SUBJECT: **SFD2403-0069**
BUILDING RESIDENTIAL

Here are the results of all Inspections located at **1423 BENHAVEN SCHOOL RD:**

**1 HOUSE FOUNDATION PLAN**  
 S1 SCALE: 3/16" = 1'-0" APPROX

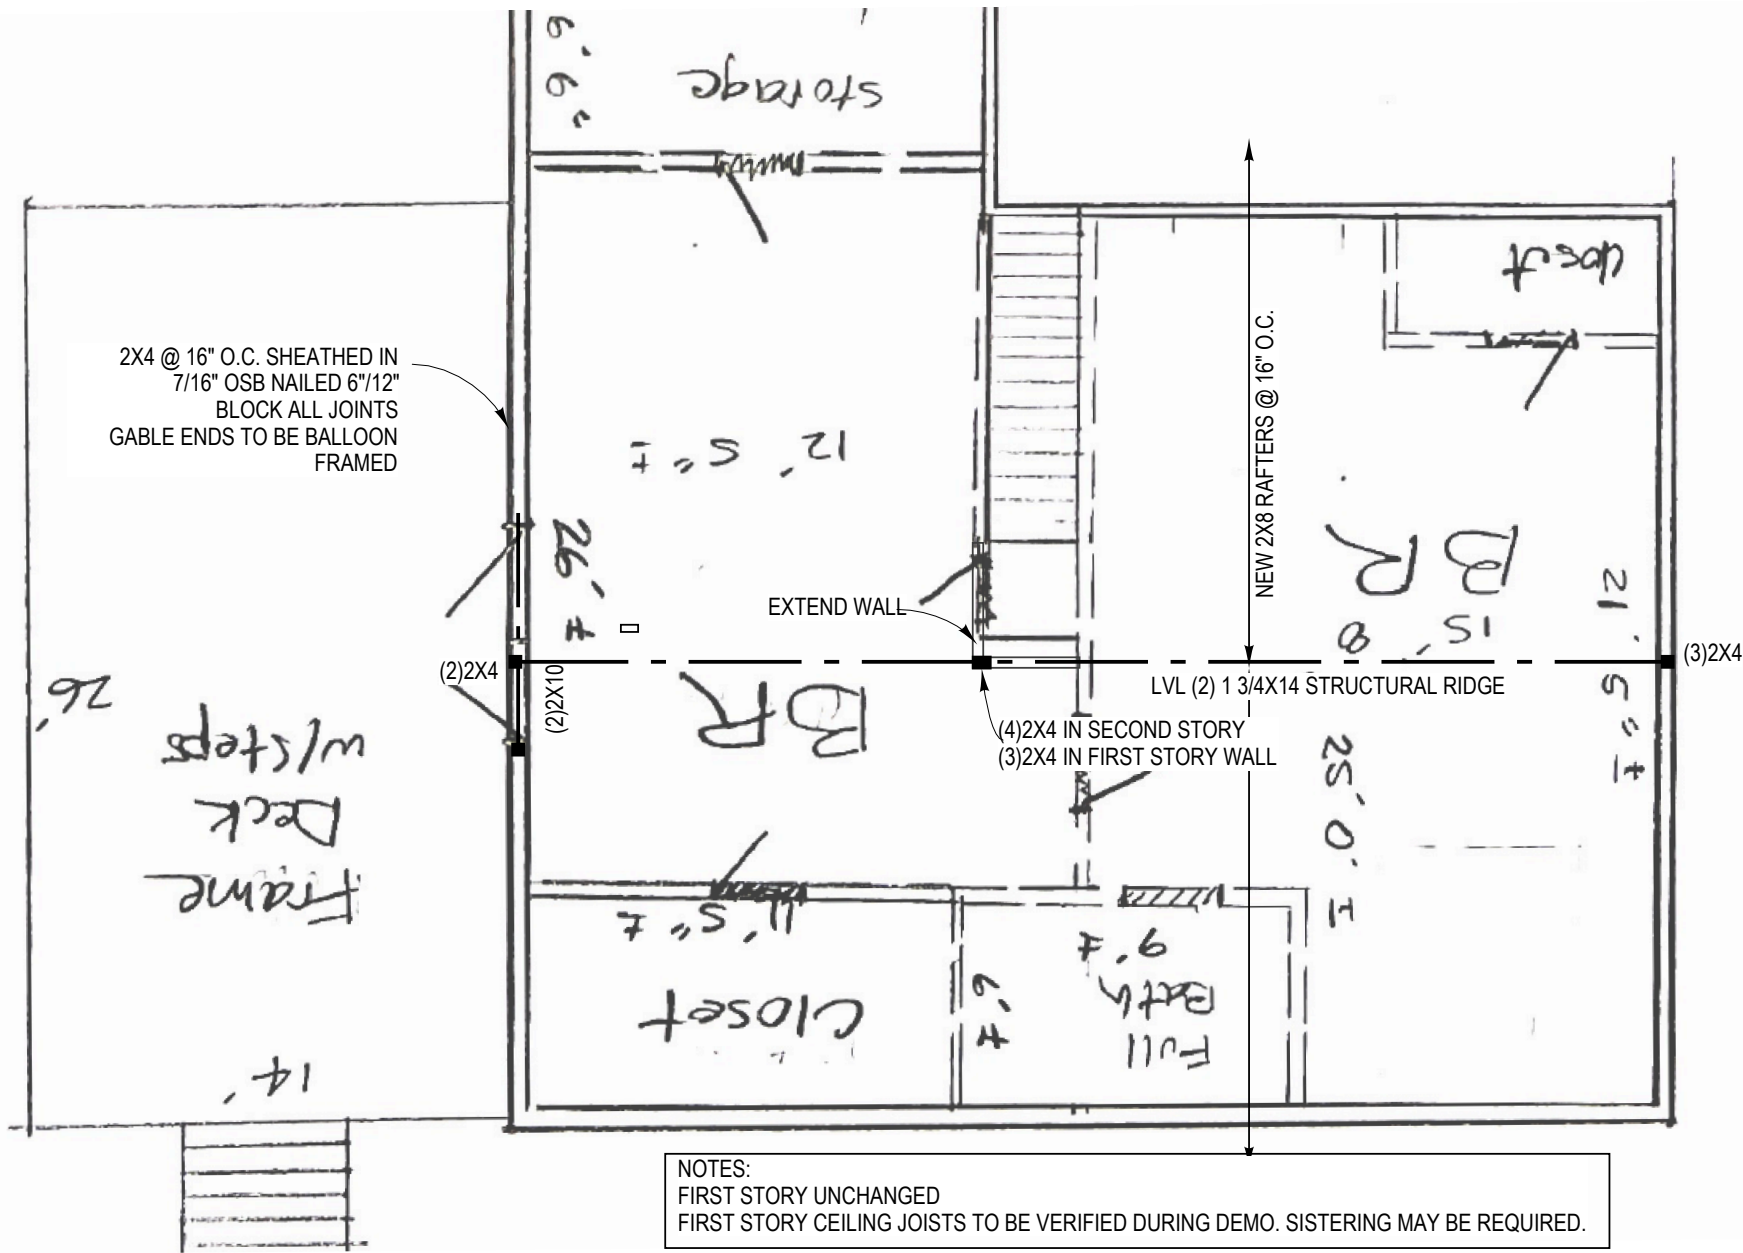
Inspection Type: FOOTING
Scheduled Date/Time: 5/22/2024
Completed Date/Time: 5/22/2024
Inspector: Steven Gazlay
Result: DISAPPROVED
Remarks:
Notes: Post address at road. Missing portable toilet. Engineered footings must be per plan. Missing pour depth markers on piers.

Inspection Type: FOOTING
Scheduled Date/Time: 5/29/2024
Completed Date/Time: 5/29/2024
Inspector: Steven Gazlay
Result: FAIL W/ PENALTY
Remarks:
Notes: Footings must be per plan, for size and layout.

Inspection Type: FOUNDATION
Scheduled Date/Time: 10/10/2024
Completed Date/Time: 10/10/2024
Inspector: Ricardo D Honrada
Result: DISAPPROVED
Remarks:
Notes: Follow the foundation plan. Anchor bolts not strap. 24X24 CMU under the chimney. 8X16 CMU pilaster as shown. 2 pcs. 16X24 supporting back porch

Inspection Type: FOUNDATION
Scheduled Date/Time: 10/29/2024
Completed Date/Time: 10/29/2024
Inspector: Daniel L Floyd
Result: APPROVED W/EXC
Remarks:
Notes: Missing 2 piers under the porch unable to install due to I beams house is sitting on will check again when house is set on foundation.

1 SECOND STORY PLAN  
 S2 SCALE: 3/16" = 1'-0"

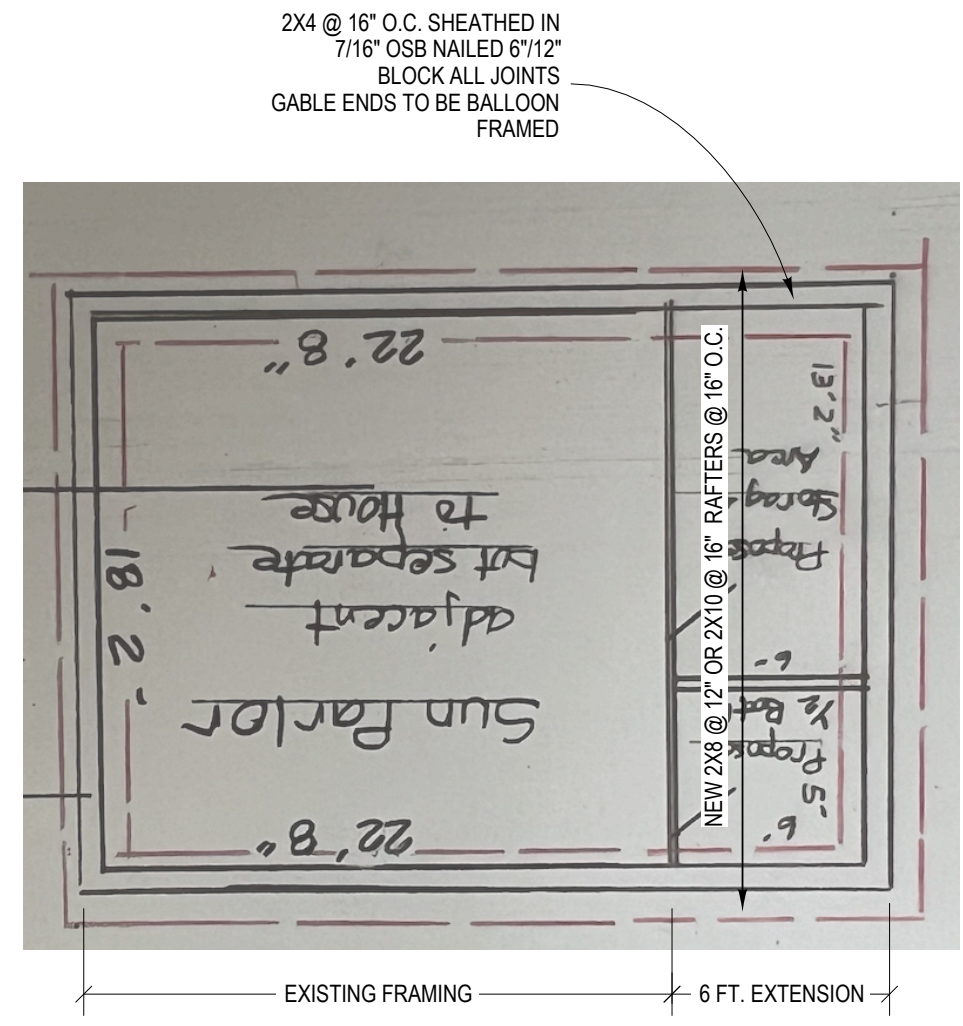
Notes: Need collar ties at living room by LVL Rafters need to bear solid on ridge beam at dormer window in the middle Two ply beam at dormer window needs to be hangers
